Application No: K/2/22/HH
Site Address: 43 Golden Avenue East Preston BN16 1QX
Description of works: 2 storey front and rear extensions and alterations.

Planning Application No. K/2/22HH - 43 Golden Avenue

Proposed Rear (East) Elevation

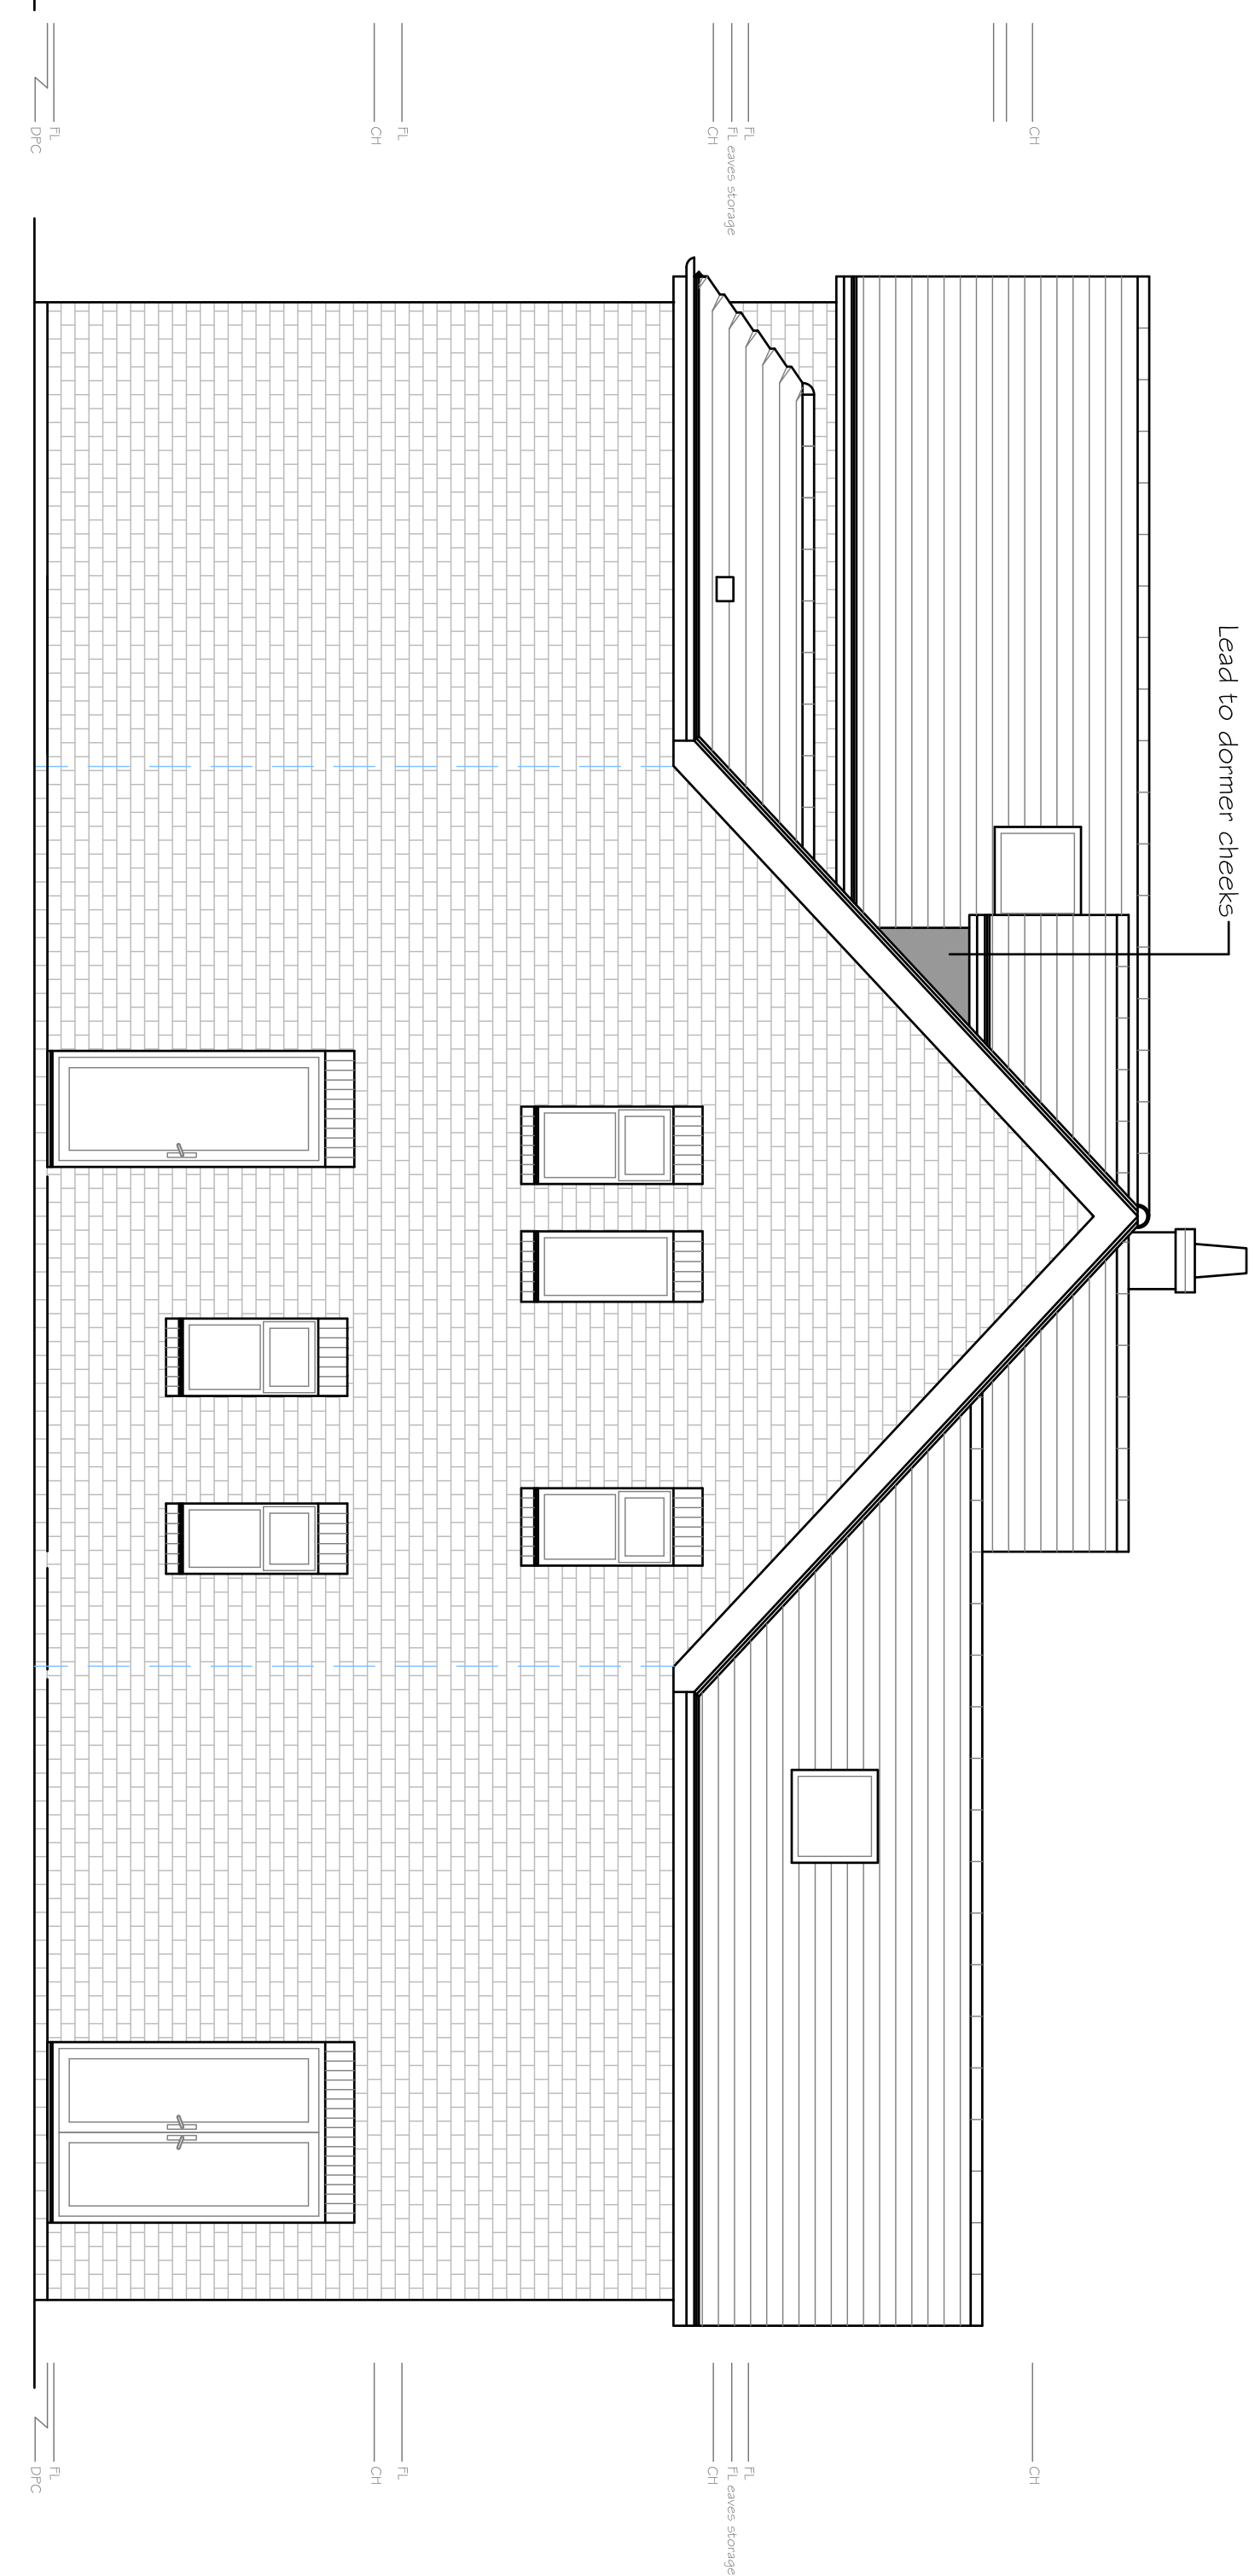
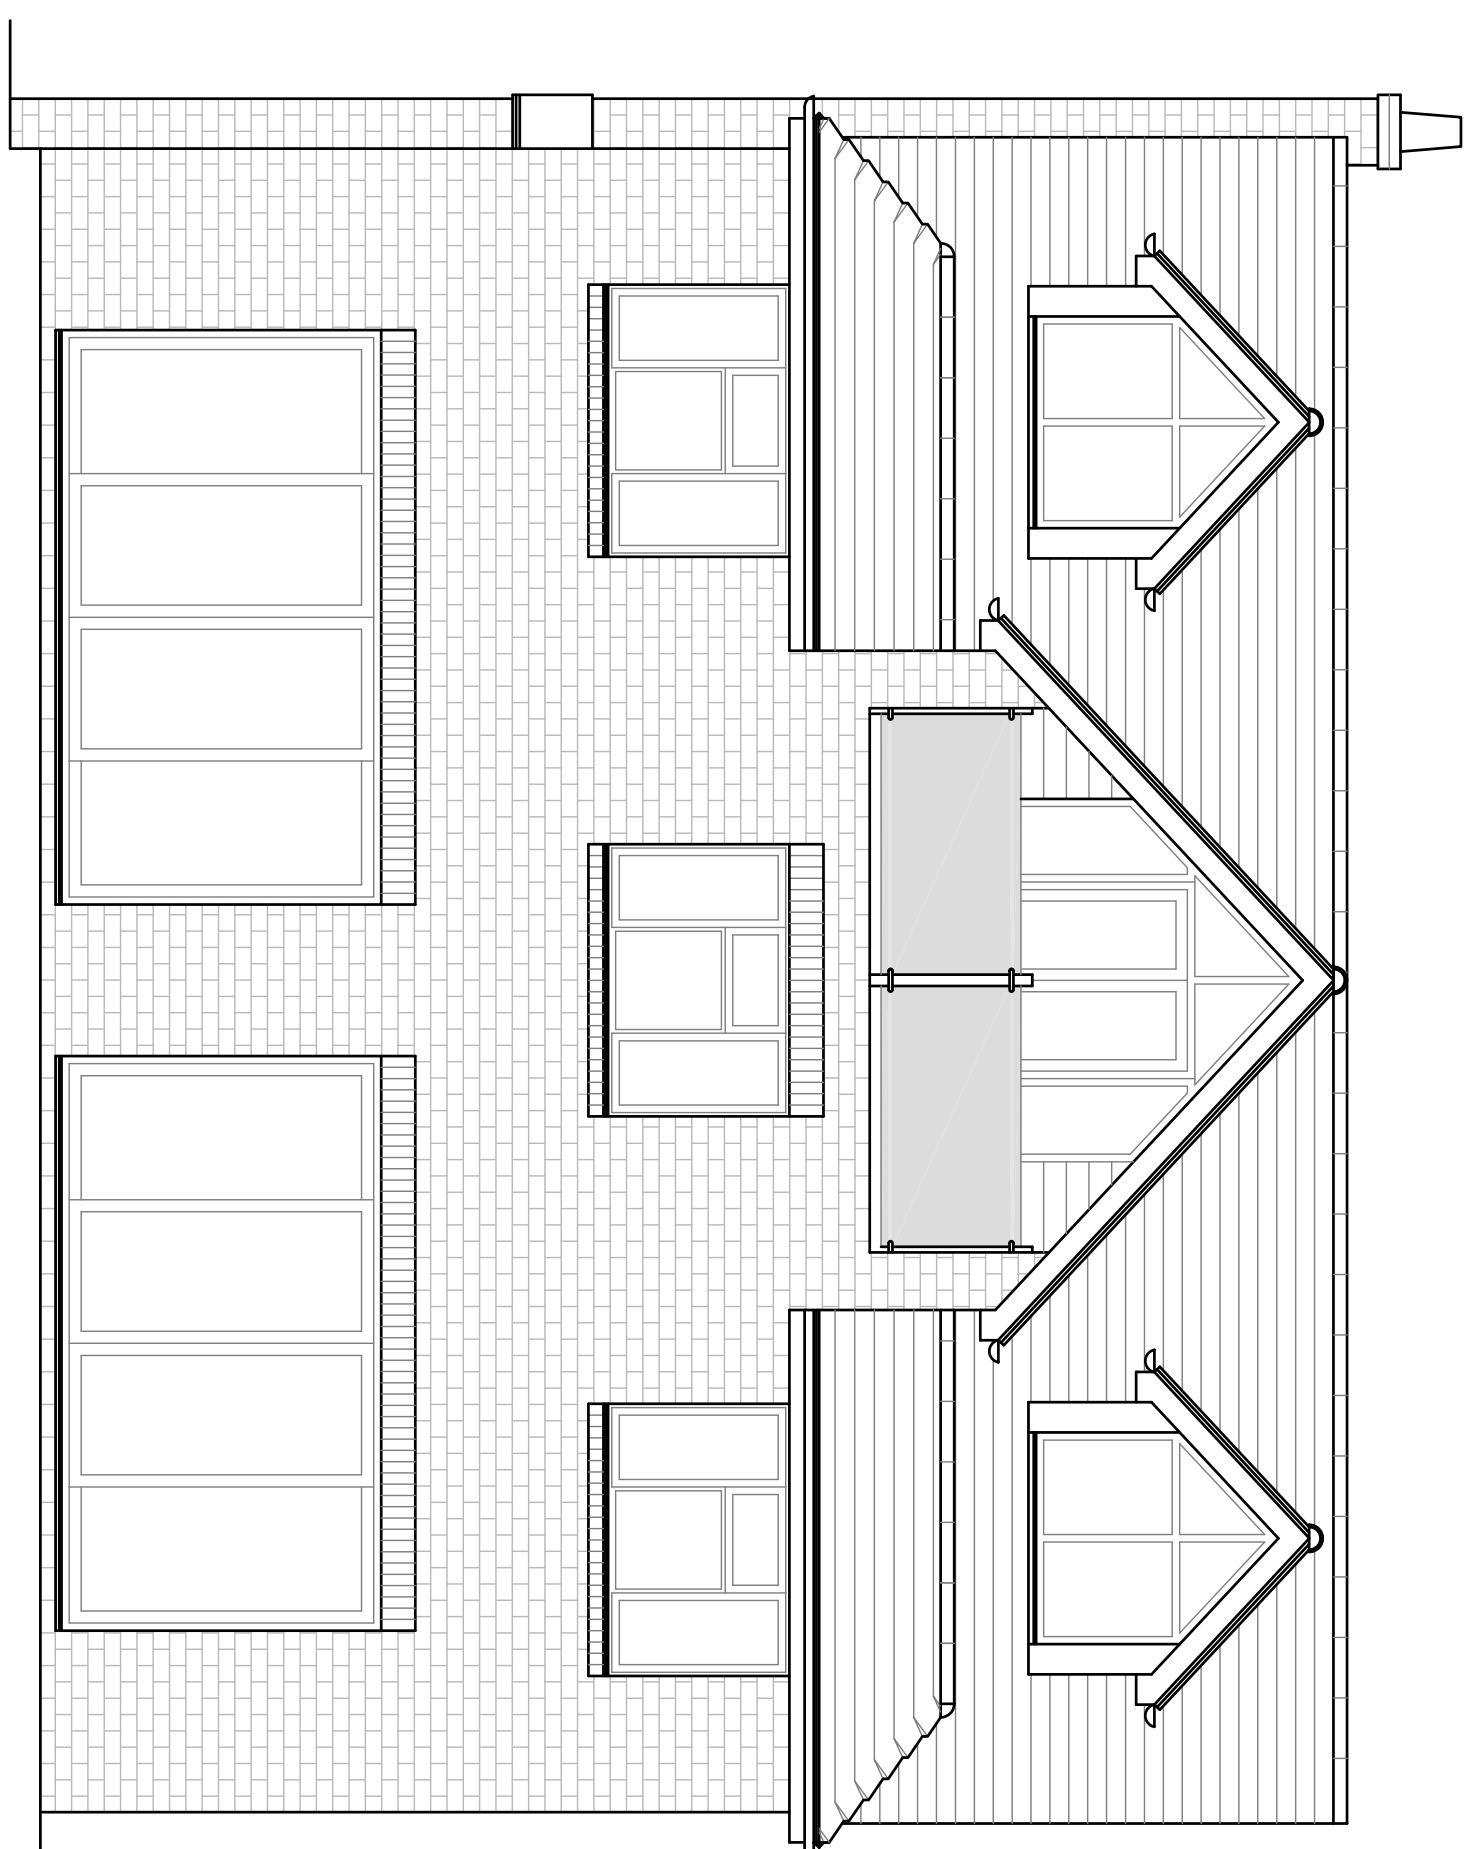
Further concerns that we have observed with the rear extension and the central roof accommodation is the depth and especially the height to the top of the central dormer styled room and roof. The consequence of

these proposals is that the windows on the first floor and the new balcony/window for the roof accommodation and to a lesser extent the roof dormer windows; they will all directly overlook into our garden and additionally will intrude on us, with the loss of our privacy.

The proposals will increase the overshadowing to our property including the loss of the natural daylight as a result of the new proposals, together with the added impact of the orientation of both properties.

The increase of overshadowing to the rear of our property will be seen as the sun moves around from east to west and passes behind the new extension and central dormer roof style roof extension, increasing the amount of shading into our garden.
